TS/D3/07/916/MRN (VF)  
25 October 2007

**TOWN AND COUNTRY PLANNING ACT 1990  
PROPOSED EXTENSION TO REAR OF EXISTING INDUSTRIAL BUILDING  
UNIT 1 THE OLD RIDING SCHOOL PARK ROAD GISBURN  
FOR ASSURED ENVIRONMENTAL SERVICES**

I am recommending refusal of this application on road safety grounds.

Proposed Ground Floor Plan

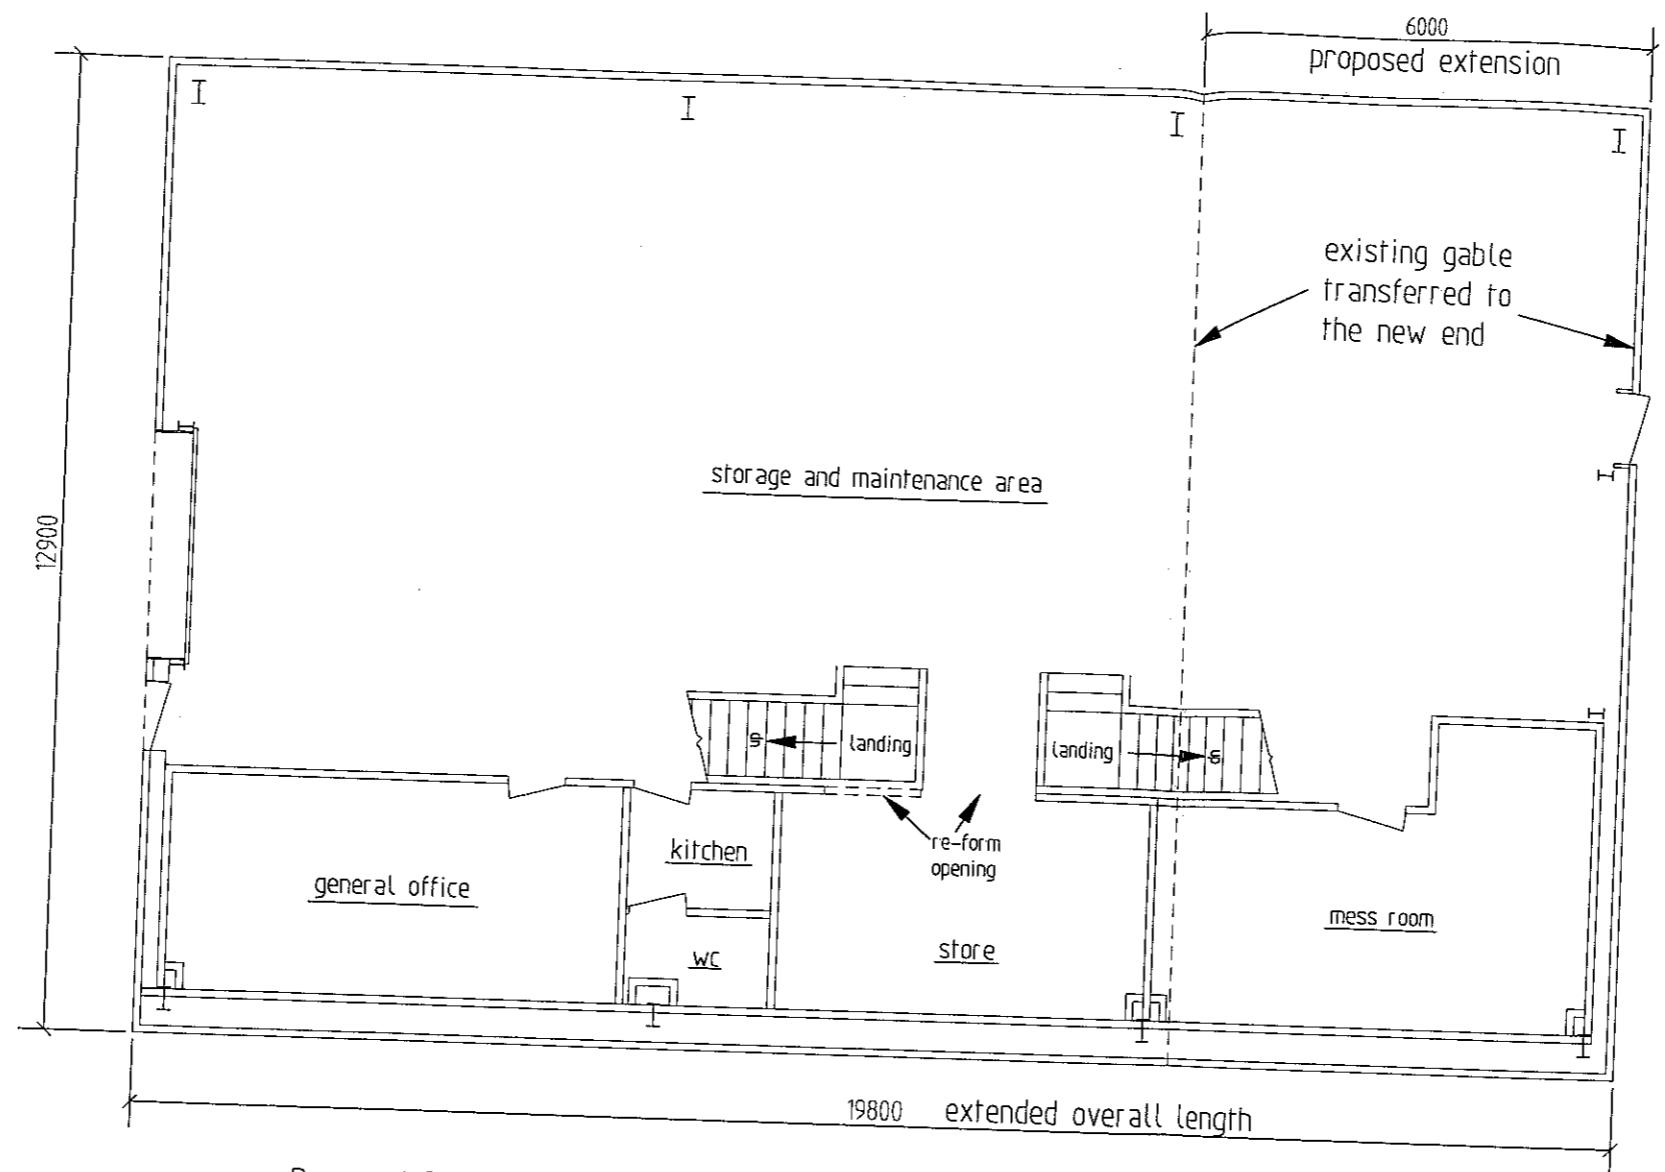
This recommendation relates specifically to the proximity of the proposed development to the adjacent retaining wall along Mill Lane, Gisburn.

A minimum 3m of land easement width for future access to maintain or eventually reconstruct the wall is necessary. This is required to permit the use of any plant, temporary works as well as materials. It would appear that as a result of the extent of the proposed development this easement width will no longer be available. This is not acceptable and the extent of the development should be revised to secure this easement for Lancashire County Council's future use
